HIGHWAY AND LEAD LOCAL FLOOD AUTHORITY RESPONSE TO CONSULTATION ON THE FOLLOWING DEVELOPMENT PROPOSAL

Application number: H23-1272-25

Proposal: Erection of 2 Houses with Garages

Location: Adjacent Carlton Lodge, Oxcroft Bank, Shepeau Stow, Spalding

BLOCK & LOCATION PLANS

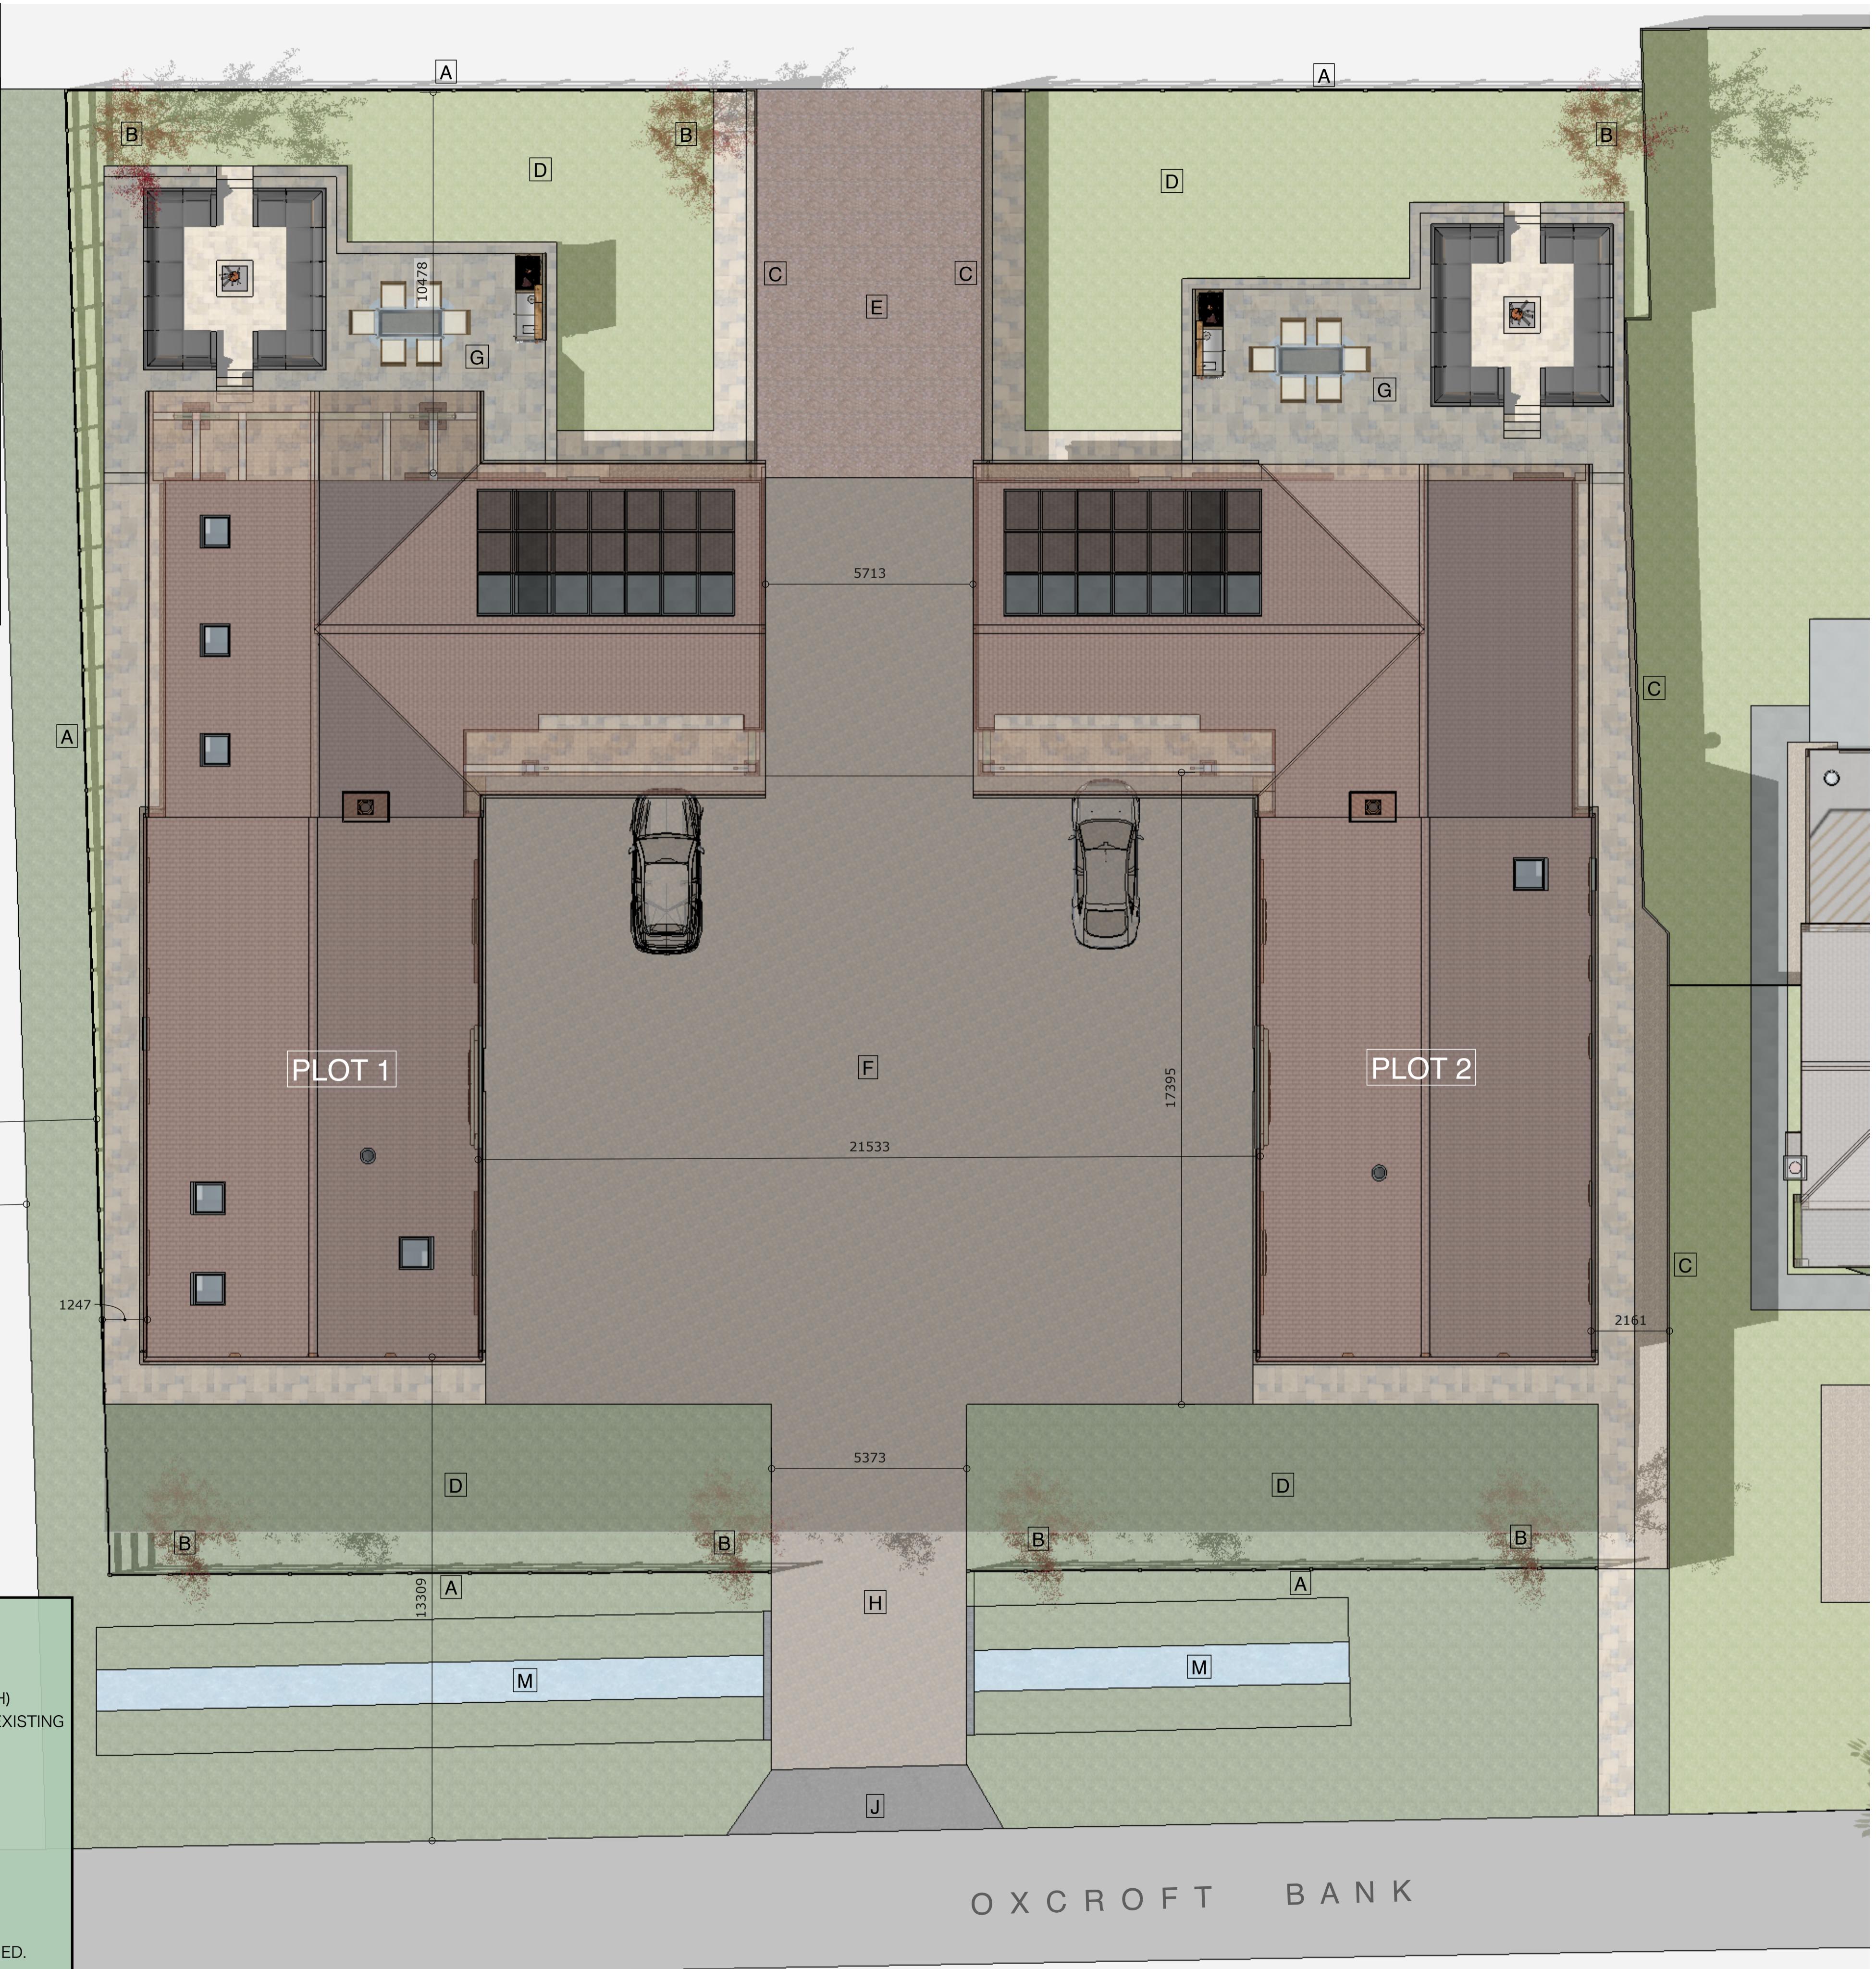
Erection of 2 Houses with Garages - This site already benefits from a live planning application for three dwellings. The parking demonstrated is acceptable for the size of the dwellings. A new access to the public highway is required and the existing access will need to be stopped up. The proposal will not have an adverse impact on the public highway. As Lead Local Flood Authority, Lincolnshire County Council is required to provide a statutory planning consultation response with regard to drainage and surface water flood risk on all Major applications. This application is classified as a Minor Application and it is therefore the duty of the Local Planning Authority to consider the surface water flood risk and drainage proposals for this planning application.

Within seven days of the new access being brought into use, the existing access onto Oxcroft Bank shall be permanently closed in accordance with details to be agreed in writing with the Local Planning Authority.

Prior to the occupation of any dwelling the vehicular access to Oxcroft Bank shall be improved in accordance with drawing number J201-BR-1A dated Jan 26.
